Historic England

Arrangements for Handling Heritage Applications Direction 2021

**THE GROVE UNITED REFORM CHURCH, OXFORD ROAD, GOMERSAL,
CLECKHEATON, WEST YORKSHIRE BD19 4JY
Application No. 2023/90073**

Thank you for your letter of 7 February 2023 regarding the above application for listed building consent. On the basis of the information available to date, we offer the following advice to assist your authority in determining the application.

GROUND FLOOR
 1 : 100

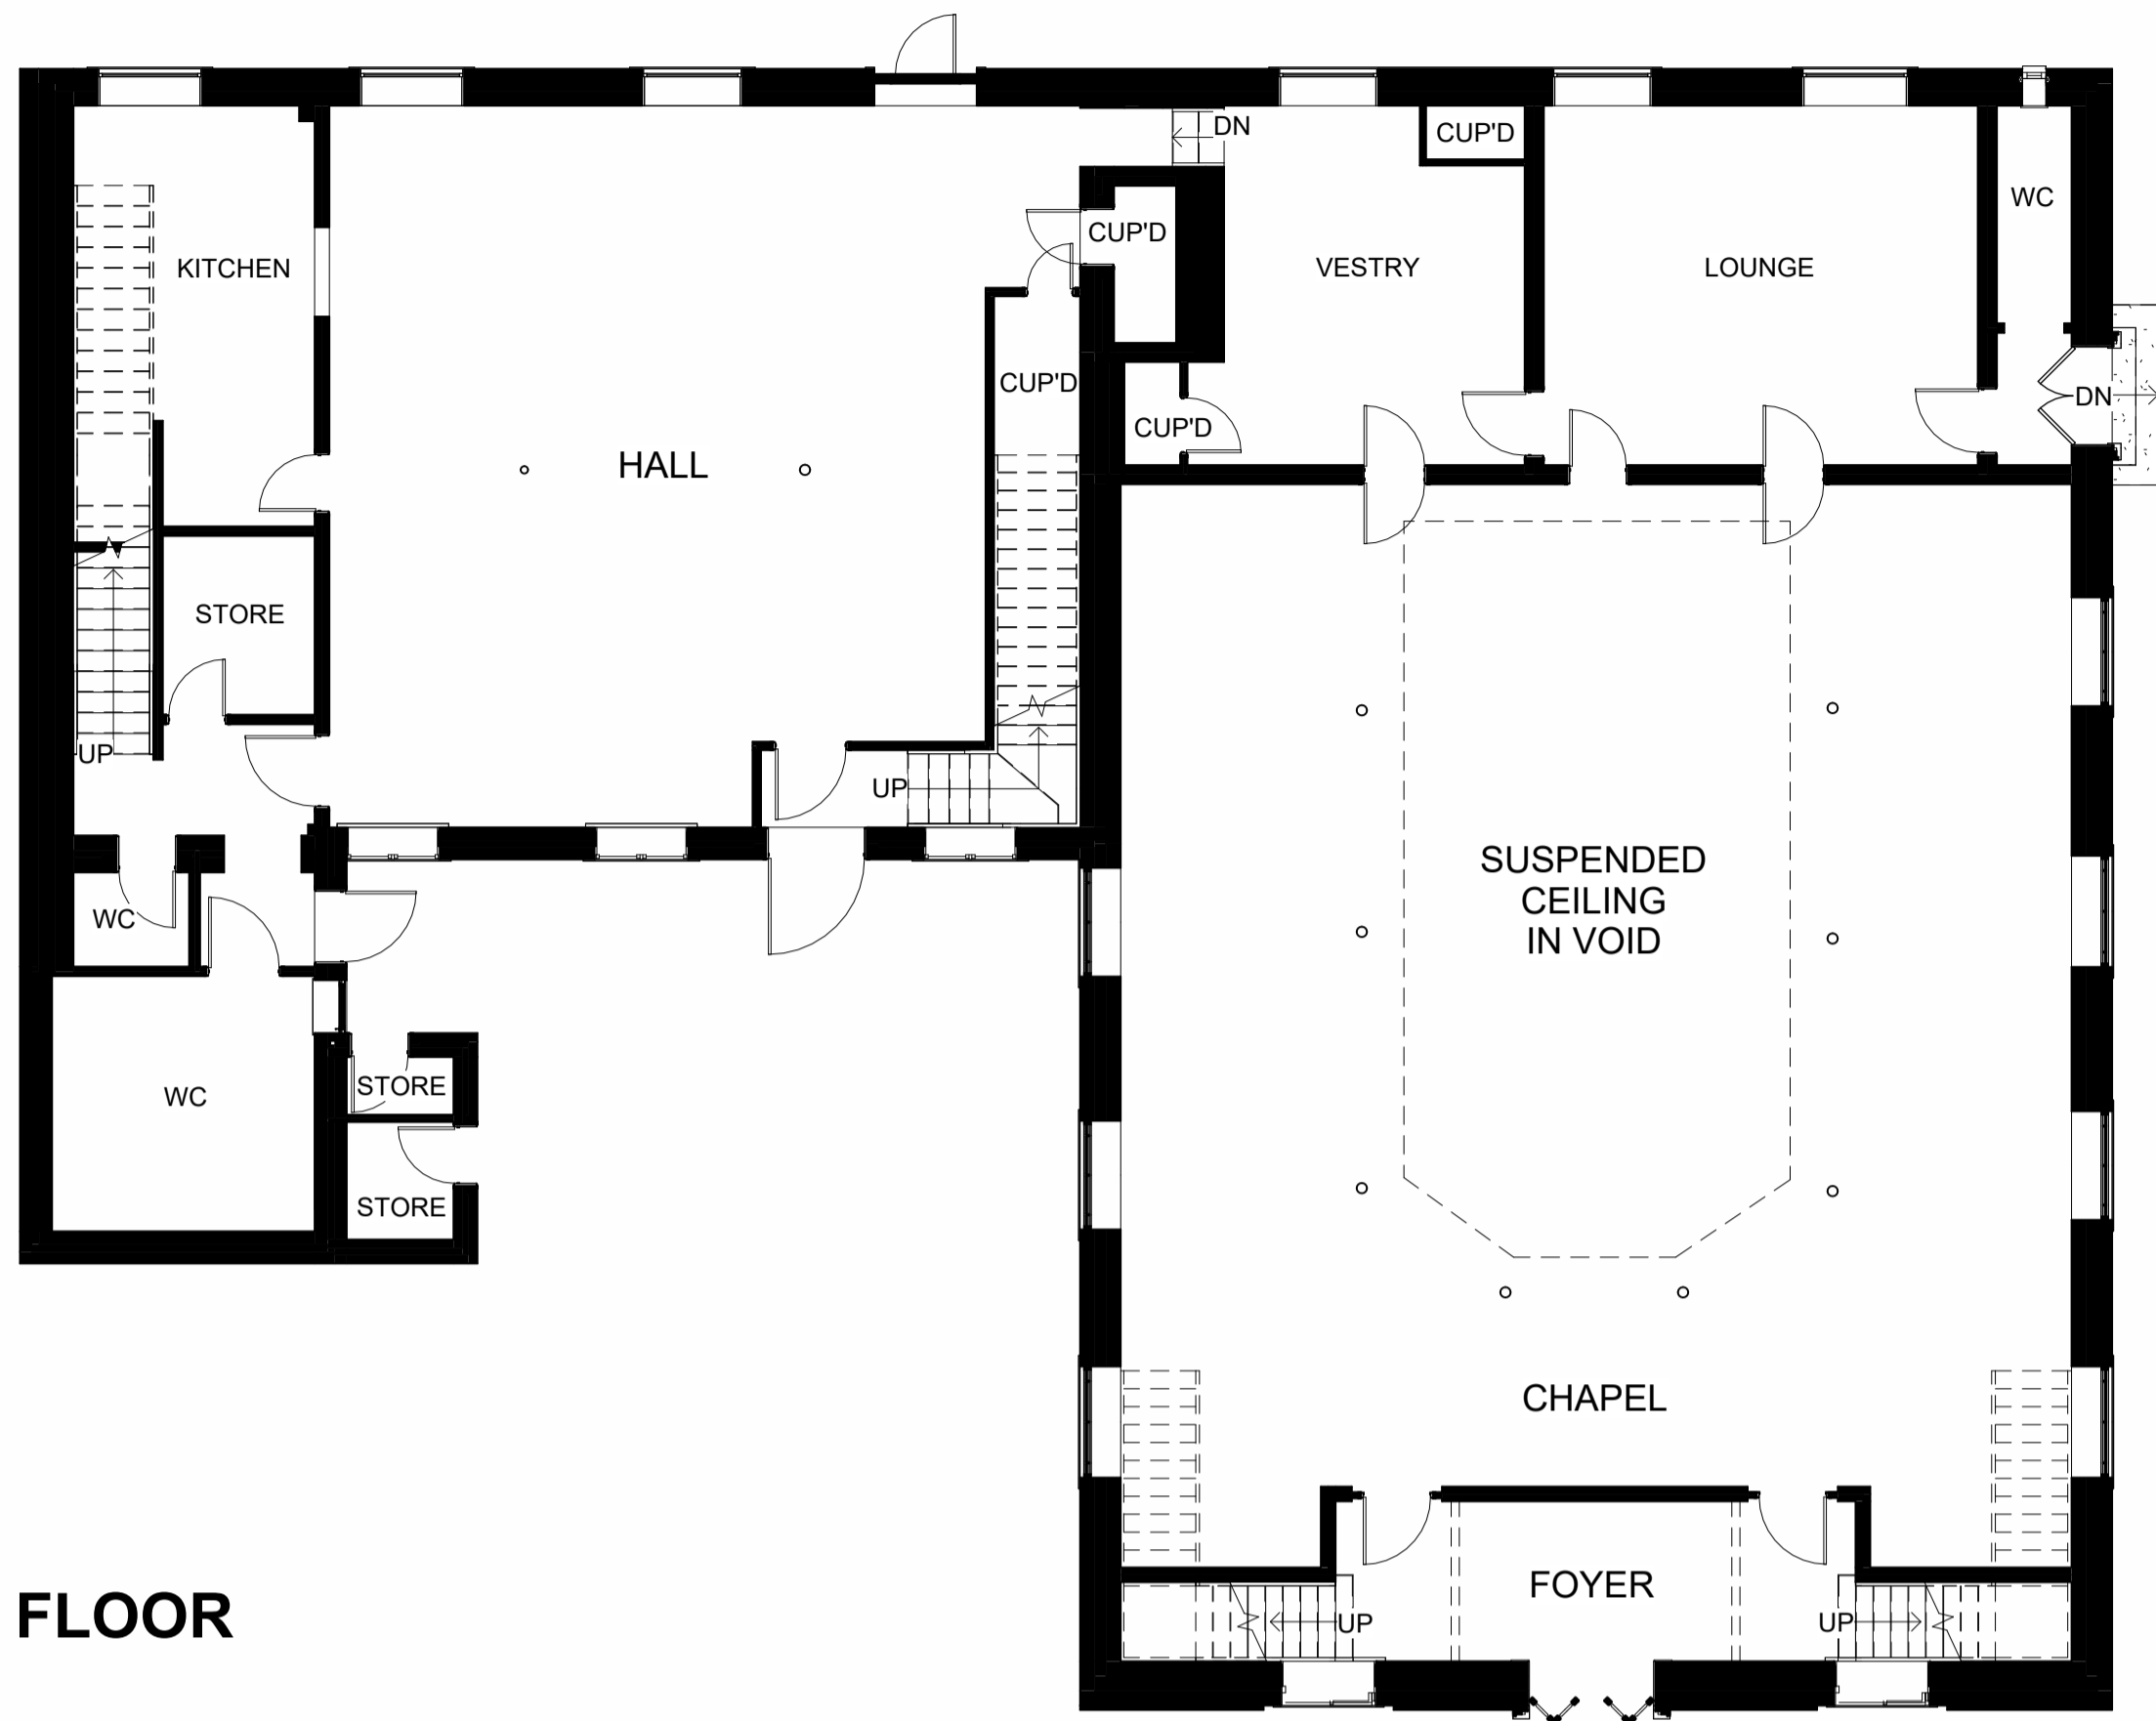
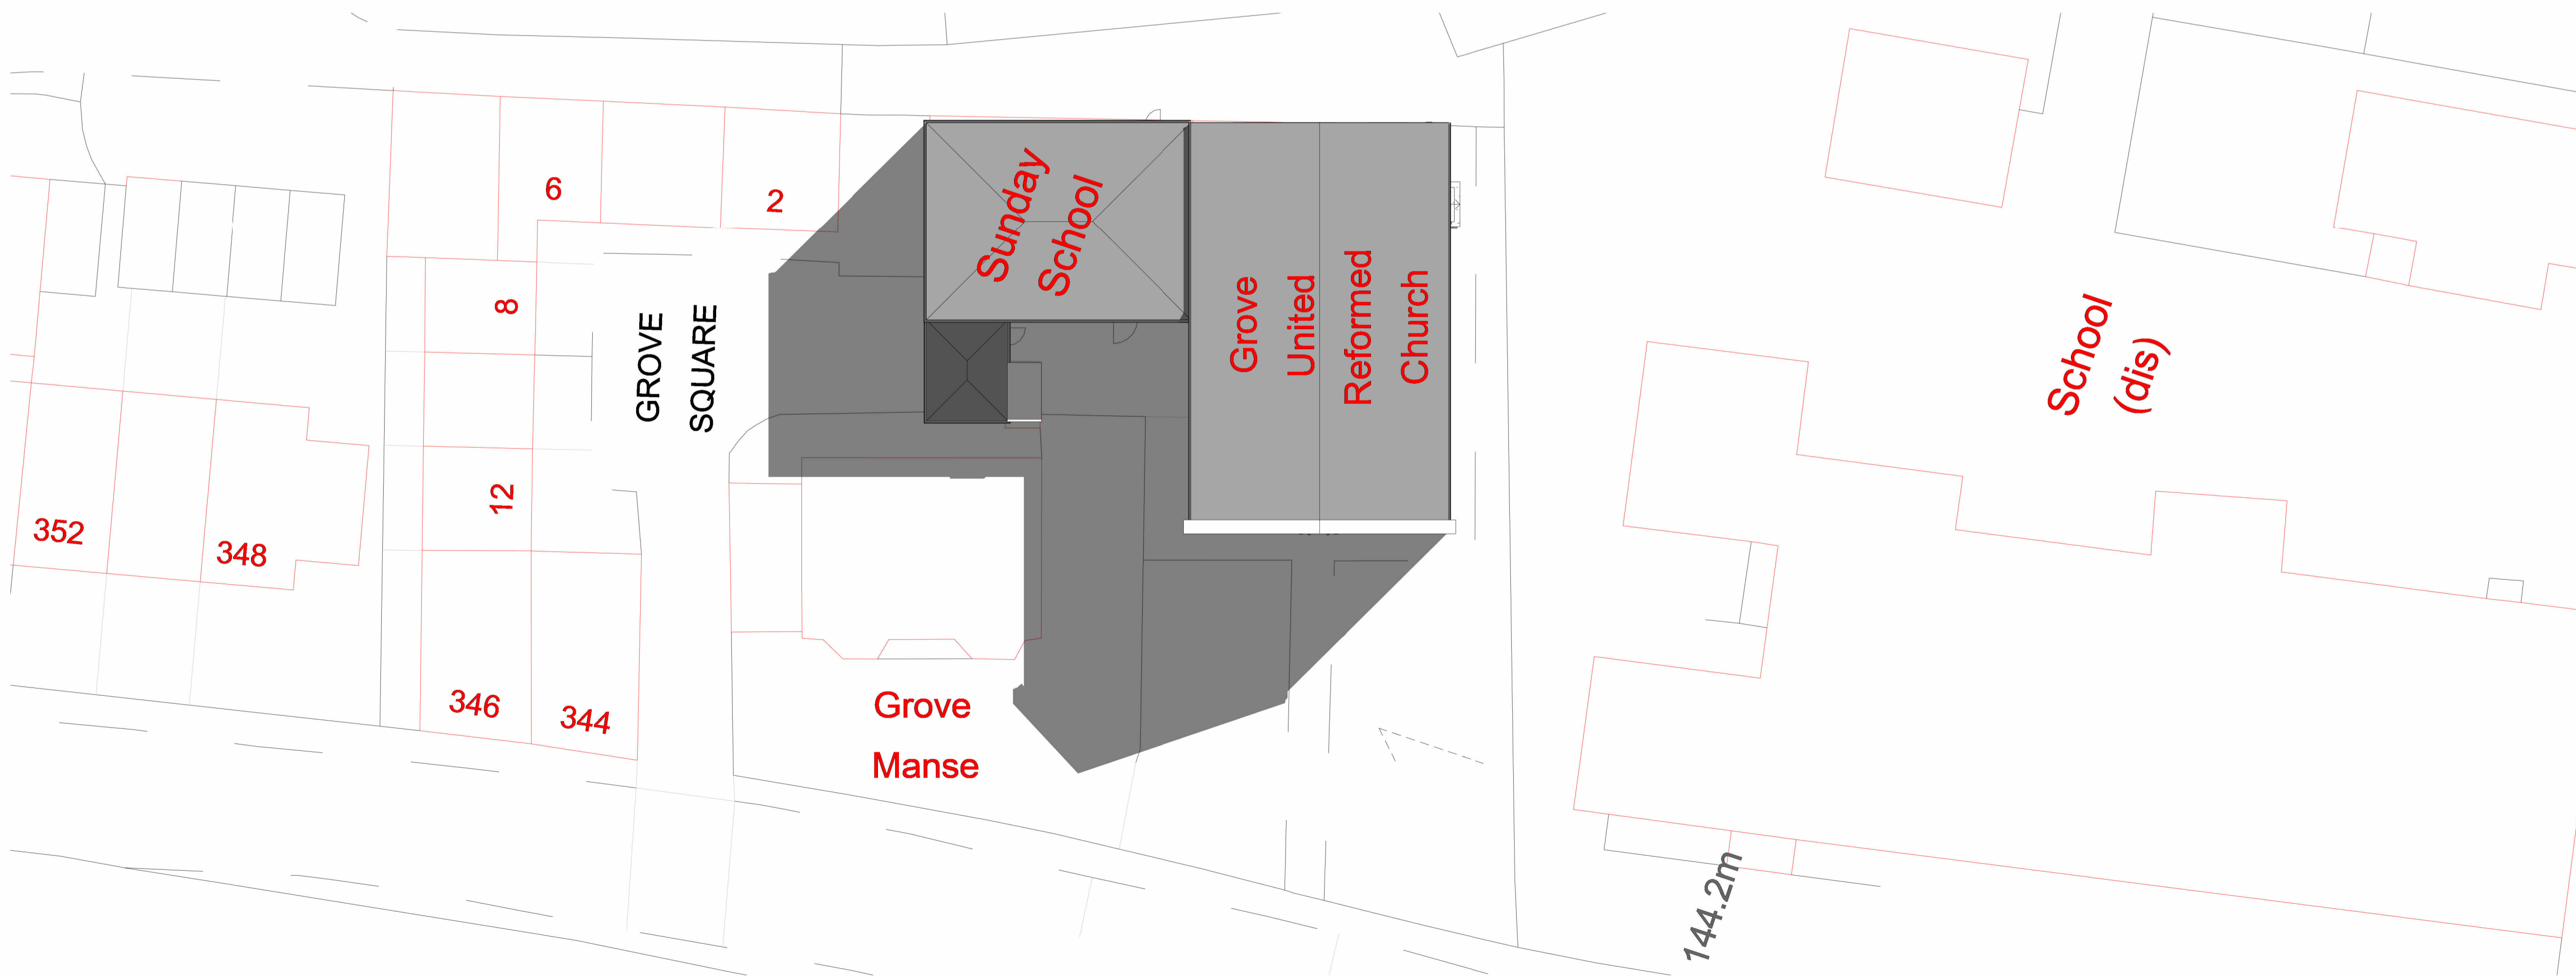
The proposed conversion of the main chapel space will result in the loss of the existing pews, pulpit and rail. The proposed subdivision of the space into apartments will also impact on the legibility of the original gallery and double-height space. This will cause harm to the significance of the grade II listed building as an example of an early nineteenth-century non-conformist chapel. There are some elements of the design that seek to mitigate this harm, for example the retention of the original pair of staircases, the retention of columns and the creation of a double-height space within two of the units. The harm could be reduced further if a reduced number of units was proposed for the chapel building. We defer to your local knowledge to assess whether there is a "clear and convincing justification" for the intensity of the proposed redevelopment, or whether it would be viable to provide fewer, larger units which would retain more of the original spatial qualities of the building. Whatever scheme is taken forward, we recommend opportunities are also taken to retain or reuse existing joinery within the building.
